21st October 2020

Thurrock Power Ltd
1st Floor
145 Kensington Church Street
London
W8 7LP

DAS Advice: EN010092 Thurrock Flexible Power Generation Plant

Figure 2.4: Winter bird survey extent.

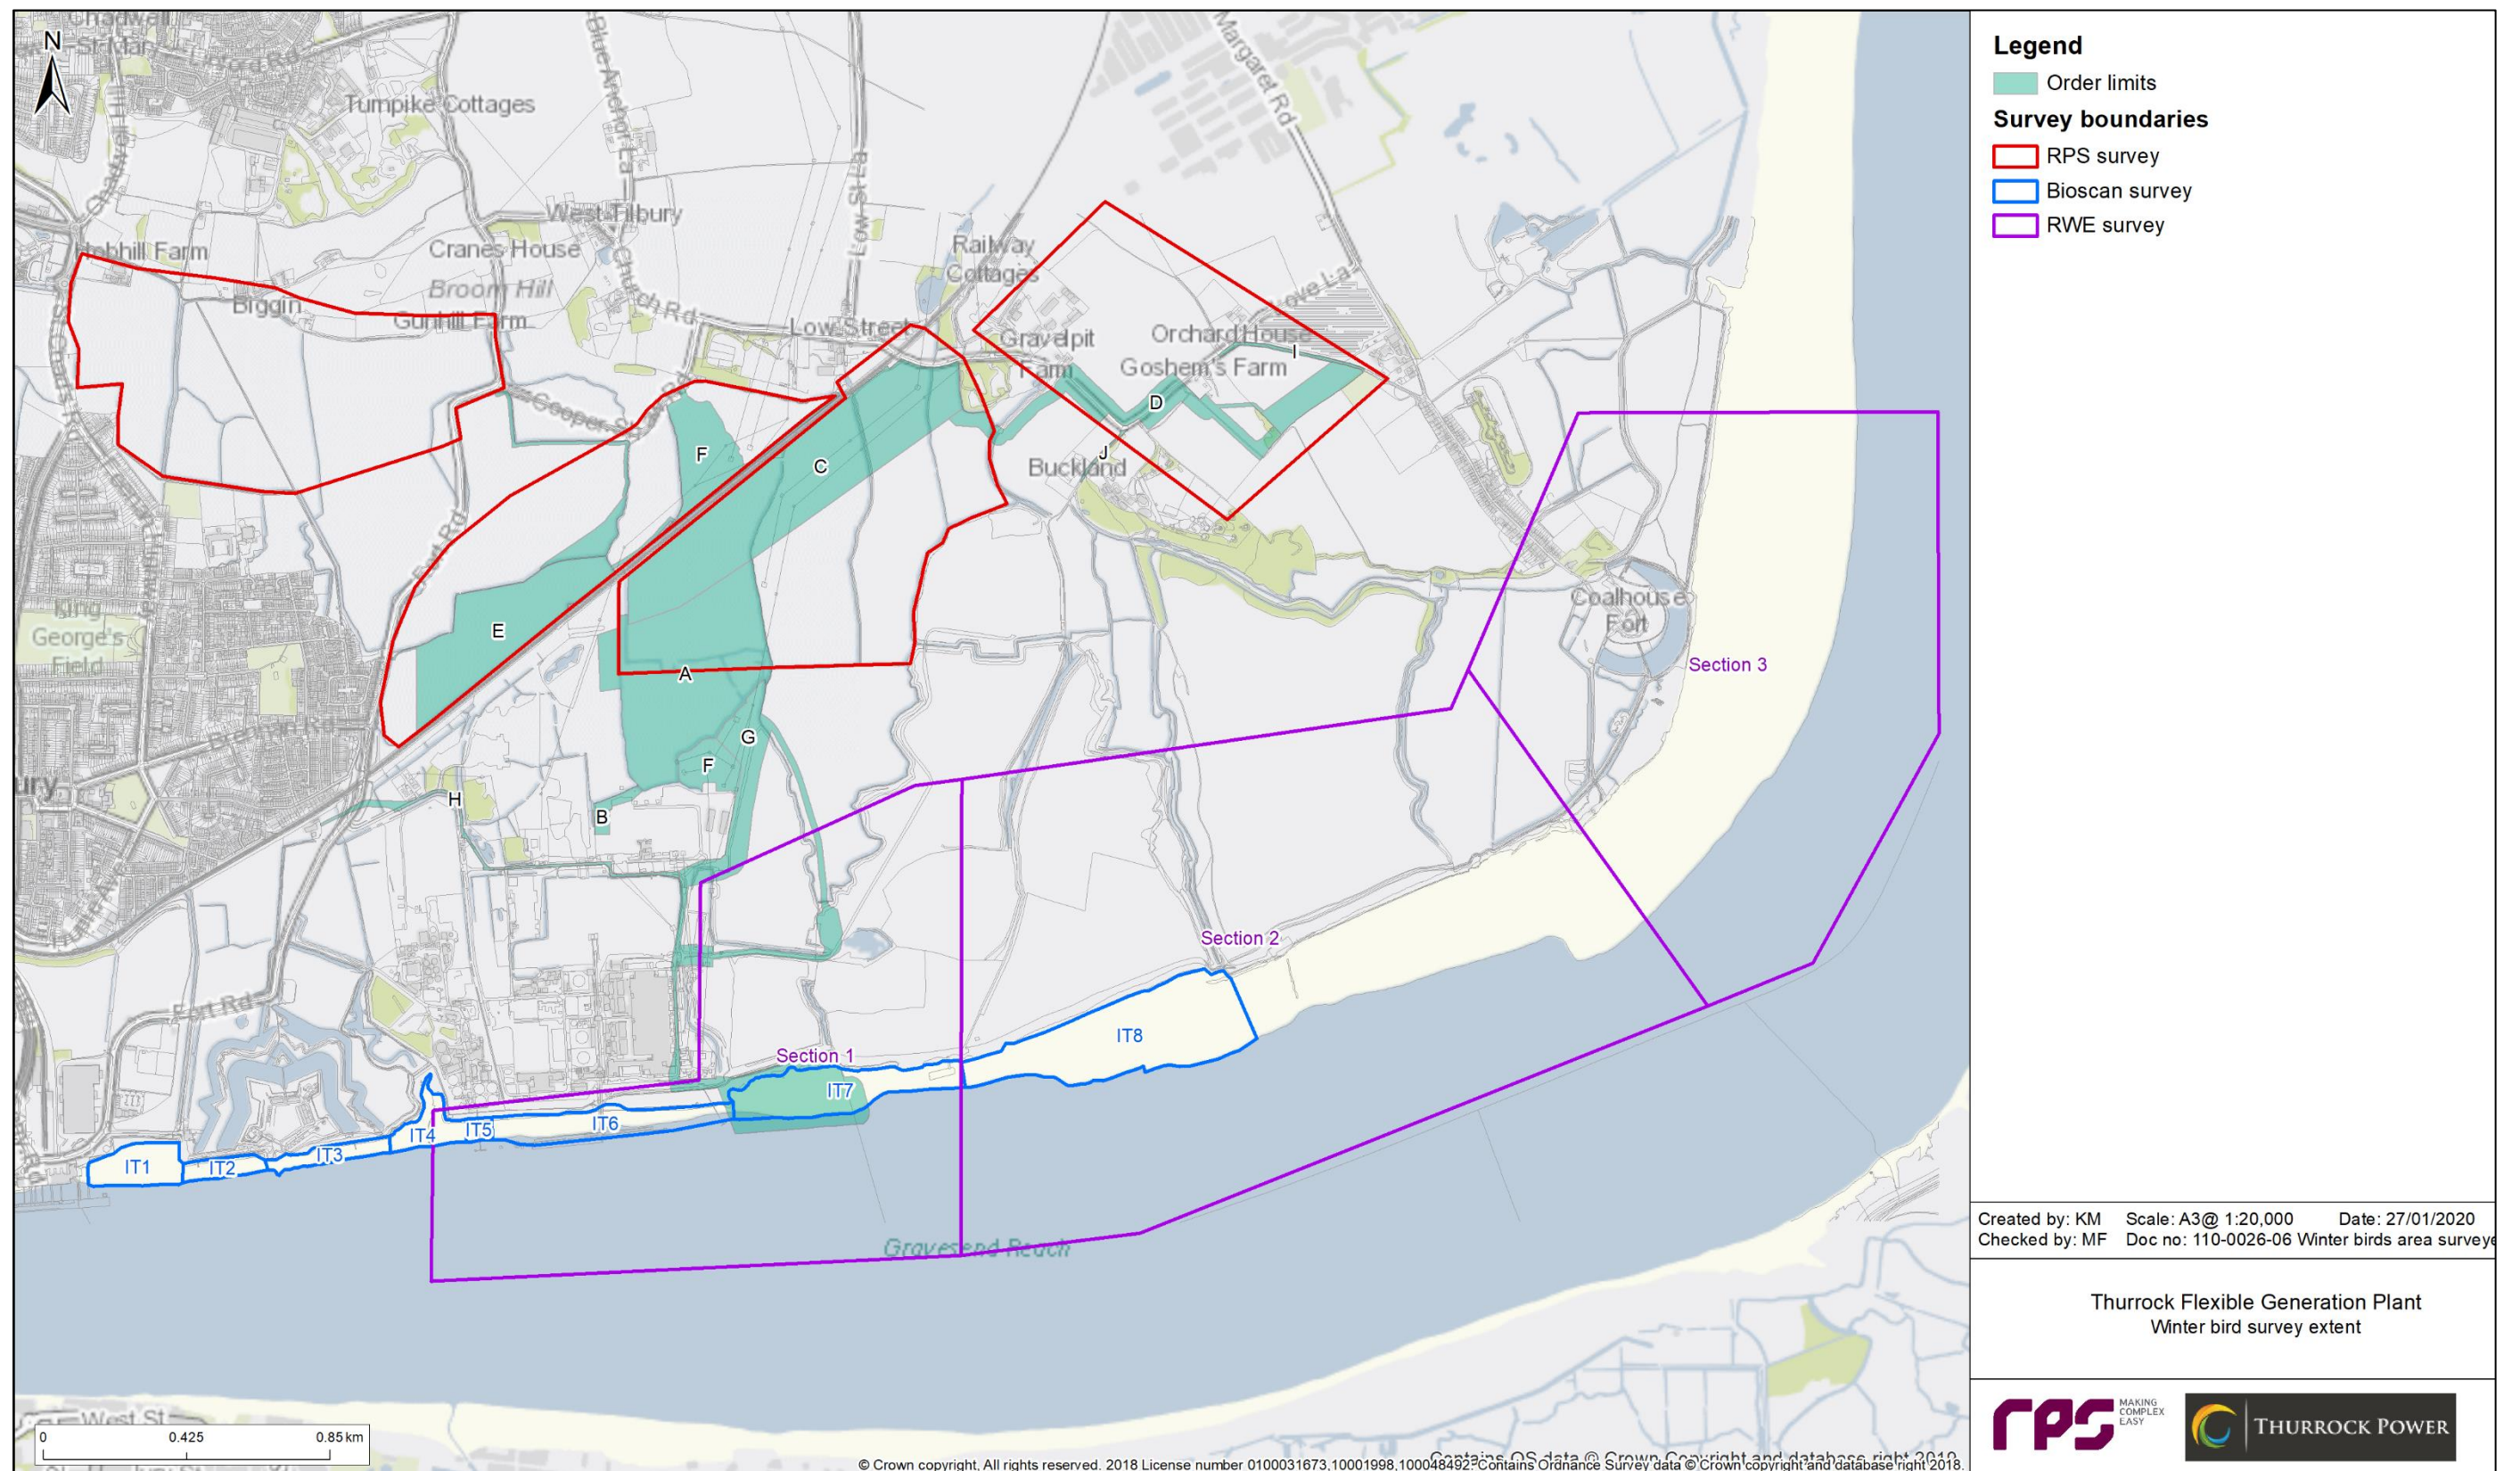
We have undertaken a more detailed assessment based upon the bird survey data collected by your team. Please note that we have not assessed ES vol. 6 Appendix 9.1 Ecological Desk Study & Surveys, but will follow up with further comments in due course. There are limitations to the survey methodology, notably only one non-breeding period (Sep 2019 – March 2020) was surveyed, which limits the capacity to make judgments about the survey count data. We advise that a consideration of the Peak over a 5 year period

and the Mean of Peak counts for individual species would enable an appropriate consideration of the peaks and natural fluctuations in species populations. For example, the value of inner Thames Estuary areas is the more sheltered intertidal habitats it provides to non-breeding birds during severe weather winters and the survey period of September 2019 – March 2020 was an exceptionally mild winter. Ensuring that an adequate extent and quality of suitable conditions exists during the harshest periods is an important role for the SPA to achieve and maintain favourable conservation status, so understanding the actual 'value' of localities supporting this habitat is very important within EIA/HRA to enable robust sustainable development solutions to be achieved. The limited submitted bird survey data therefore requires a suitably precautionary approach when assessing and drawing conclusions, and it is within this context that we advise from the survey data submitted (Table 3.1).

Avocet – peak count (Sep – March) is 44 (49 if Area 2 added) – SPA feature 100% favourable conservation status threshold is 283 and 50% SSSI favourable condition threshold is 142, so the peak survey count in Area 1 alone accounts for over 15% of the entire (Essex & Kent) SPA 100% favourable conservation status threshold and over 30% of the 50% SSSI favourable condition threshold. This is highly significant from a SPA perspective.

Ringed Plover – peak count (Sep – March) is 23 (48 if Area 2 added) – SPA feature (Essex side) 100% favourable conservation status threshold is 133 and 50% SSSI favourable condition threshold is 67, so the peak survey count in Area 1 alone accounts for over 17.3% of the SPA 100% favourable conservation status threshold and nearly 35% of the 50% SSSI favourable condition threshold. The potential effect on the Essex SPA population is highly significant from a SPA perspective. If one considers the effect on the full SPA populations covering both Essex & Kent areas the 100% favourable conservation status threshold is 1,324 so the peak survey count for Area 1 alone is 1.74% of this figure and for Area 1 & 2 is 3.6%, which is also significant from an entire (Essex & Kent) SPA perspective. This is significant from a SPA perspective so the effect on this local aggregation should be considered and counts should be considered in light of any other survey information available for reference, before screening out likely significant effects.

Dunlin – peak count (Sep – March) is 124 (165 if Area 2 added) – SPA feature (Essex side) 100% threshold is 6,333 and 50% threshold is 3,167, so the peak survey count in Area 1 & 2 accounts for 2.6% of the 100% SPA favourable condition threshold and over 5% of the 50% SSSI favourable condition threshold. The potential effect on the Essex SPA population is significant from a SPA perspective however, if one considers the effect on the full SPA populations covering both Essex & Kent areas the 100% favourable conservation status threshold is 29,646 so the peak survey count for Area 1 & 2 is less than 0.6% of this figure, which is not significant from an entire (Essex & Kent) SPA perspective. In this situation, the effect on this local Essex aggregation should be considered in an SPA context, and counts should be considered in light of any other survey information available for reference, before screening out likely significant effects.

Redshank – peak count (Sep – March) is 3 (7 if Area 2 added) - SPA feature (Essex side) 100% threshold is 273 and 50% threshold is 137, so the peak survey count in Area 1 & 2 accounts for over 2.5% of the 100% SPA favourable condition threshold and over 5% of the 50% SSSI favourable condition threshold. The potential effect on the Essex SPA population is significant from a SPA perspective however, if one considers the effect on the full SPA populations covering both Essex & Kent areas the 100% favourable conservation status threshold is 3,251 so the peak survey count for Area 1 & 2 is 0.2% of this figure, which is not significant from an entire (Essex & Kent) SPA perspective. In this situation, the effect on the local Essex aggregation should be considered in an SPA context, and counts should be considered in light of any other survey information available for reference, before screening out likely significant effects.

The Bird report does not clarify what the birds are using the site for (e.g. low tide feeding, high tide roosting etc.) or the relationship of that activity to the tidal state. The peak counts suggest that the site is being used in both high tide (e.g. 26 Nov & 12 Dec) and low tides (3 Dec & 16 Mar). Given that some counts come and go it could be a key site at particular points of tidal cycle or just a transient site in the wider landscape (see previous points about four key species, above).

Figure 5.1: Maximum increase in depth averaged suspended sediment concentration during 14 days of WID - Scenario 1 (HR Wallingford, 2017).

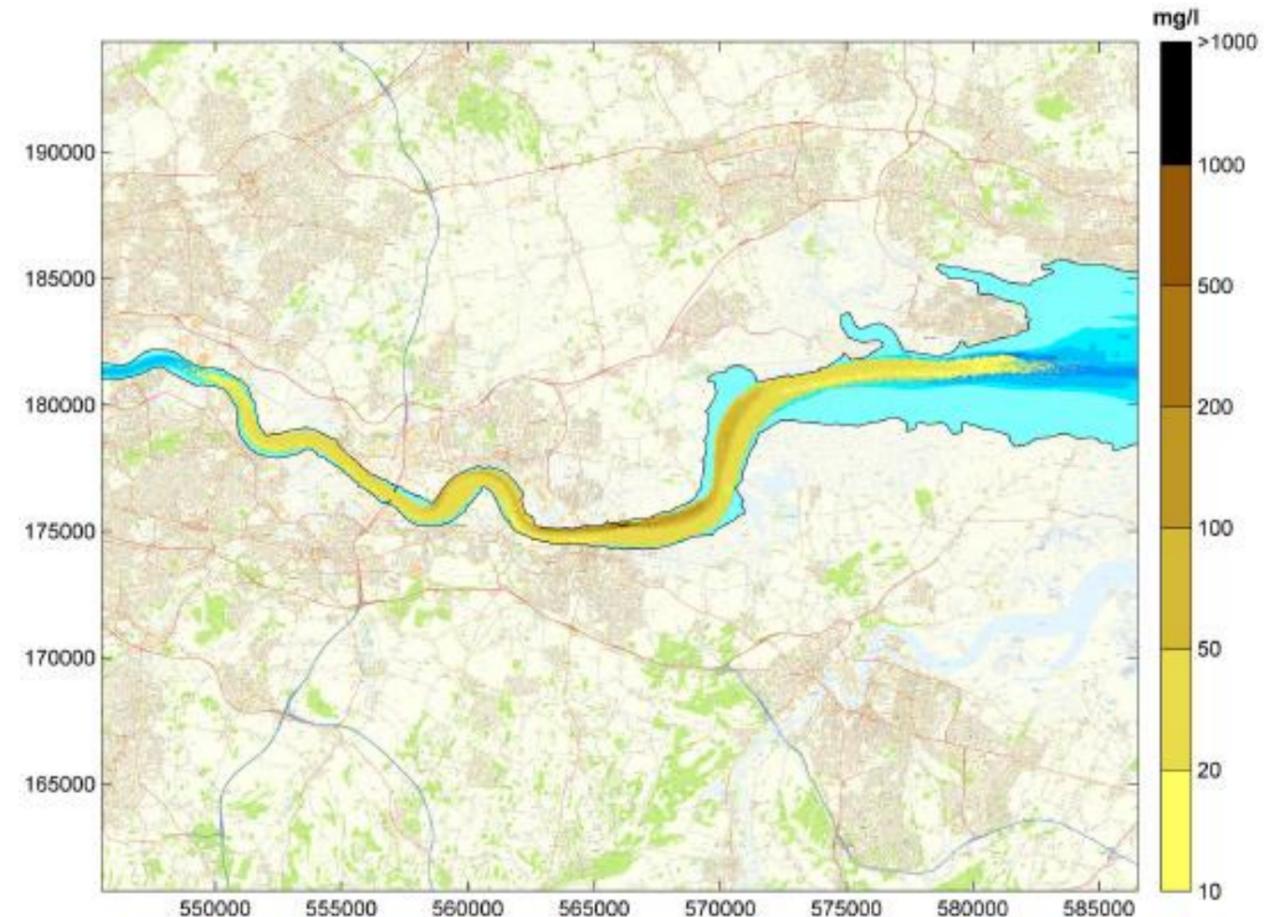
Zone of Influence from Sediment Plume - Natural England would like to see the Zone of Influence (ZOI) for the sediment plume created by the proposed works mapped for a full range of tidal conditions before we can consider the ES to be complete. We would like to see evidence that the plume will not settle in the MCZ and effect potential sites for Tentacled Lagoon Worm outside the MCZ.

Figure 1.1 Proposed causeway structure.

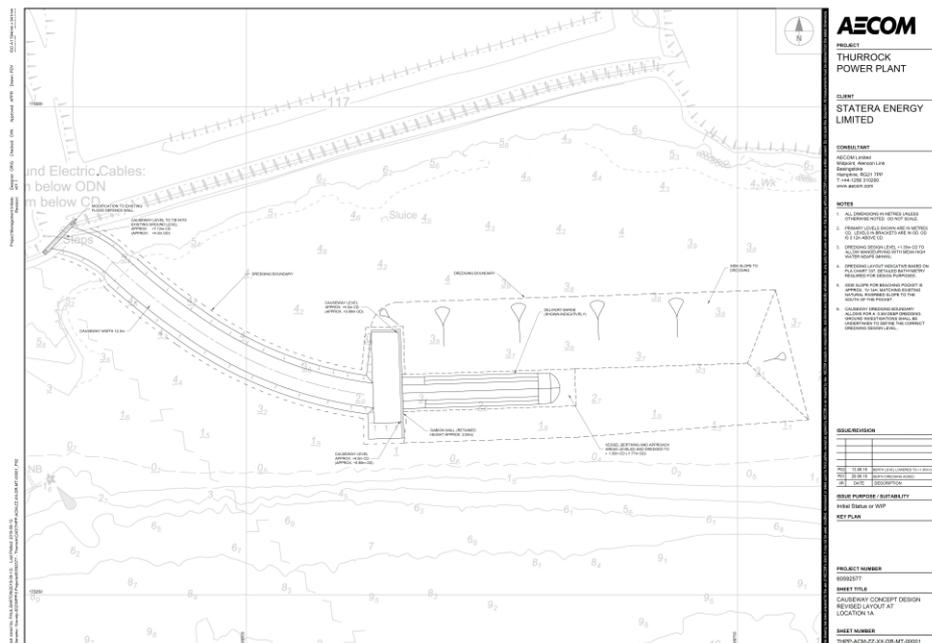
‘Permanent’ nature of the causeway - whilst the length of time the causeway is anticipated to be in situ is generally described as temporary in the submission document, in our opinion that the extended timescales (up to 50 years) should be regarded as effectively permanent for the purpose of the assessment. In our view, and with local precedent (Lower Thames Crossing use of the Goshem’s Farm jetty) temporary effects should be considered not longer than 5 years.

Overall Natural England is concerned that the causeway structure as presented in the submission reports introduces a level of activity within the foreshore that can be expected to cause prolonged disturbance and establish the principle of river-side access for the foreseeable future. We have consistently advised major development projects in this area that this is undesirable from an SPA perspective, noting that the area of foreshore broadly between Tilbury and Coalhouse Forts is functionally linked land to the nearby SPA. Proposals that introduce access and associated disturbance activities are likely to compromise this function to some degree without necessary controls. We have a number of concerns in this regard, which we set out below:-

There are a number of factors that may lead us to conclude that a temporary causeway, permitted for a short length of time would be more appropriate. With this in mind, we would like to propose that a revised proposal for a temporary causeway of 5 years duration would be more likely to receive a favourable response from Natural England. We suggest that any future use beyond this period could be achieved via a re-application to extend the life of the structure when more detailed information is available regarding its future use for the project’s purposes. These points were raised in our recent meetings on 25th September and 5th October.

Figure 2.2 Existing saltmarsh and predicted area of saltmarsh development. Soft border indicates exact area of saltmarsh colonisation cannot be exactly predicted

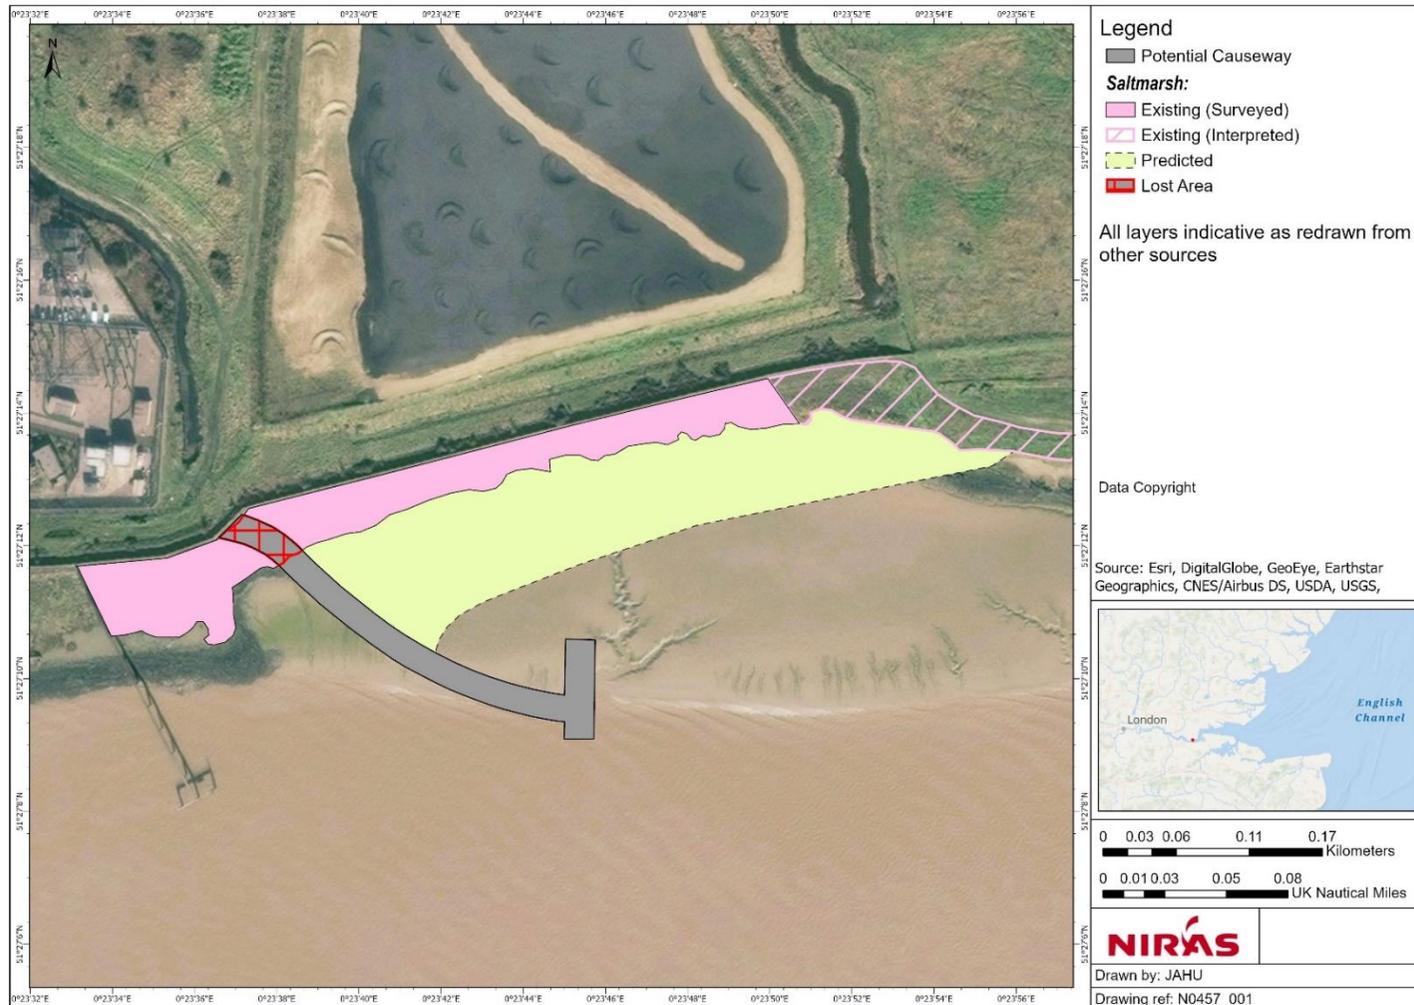
Furthermore, whilst the causeway construction may lead to saltmarsh creation (although see our Relevant Representation for uncertainties in this regard), the birds are more likely to be deriving value from the mudflat than the saltmarsh (assuming the marsh is ungrazed) and therefore the mudflat is the prime consideration. Thus the 'trade-off' between mudflat and saltmarsh is not equitable from an ecological point of view in this context.

In addition with sea level rise the surface is likely to become inundated by sediment in due course and with the shipping channel on the seaward side of the causeway and more saltmarsh adjacent to the land on the inner side of the causeway, the mudflat is likely to become steeper in gradient and reduced in surface area resulting in reduced value to species, like avocet, that wade and feed in the shallows.

The creation of intertidal habitat is developed further in 'Outline Saltmarsh Enhancement & Maintenance Plan'. However we note mud may be removed through dredging and expect that this is very likely to be contaminated. Therefore suitable assessment and adequate pollution containment will be required, both of which have implications for the methodologies chosen for the works and the subsequent use of the materials dredged.
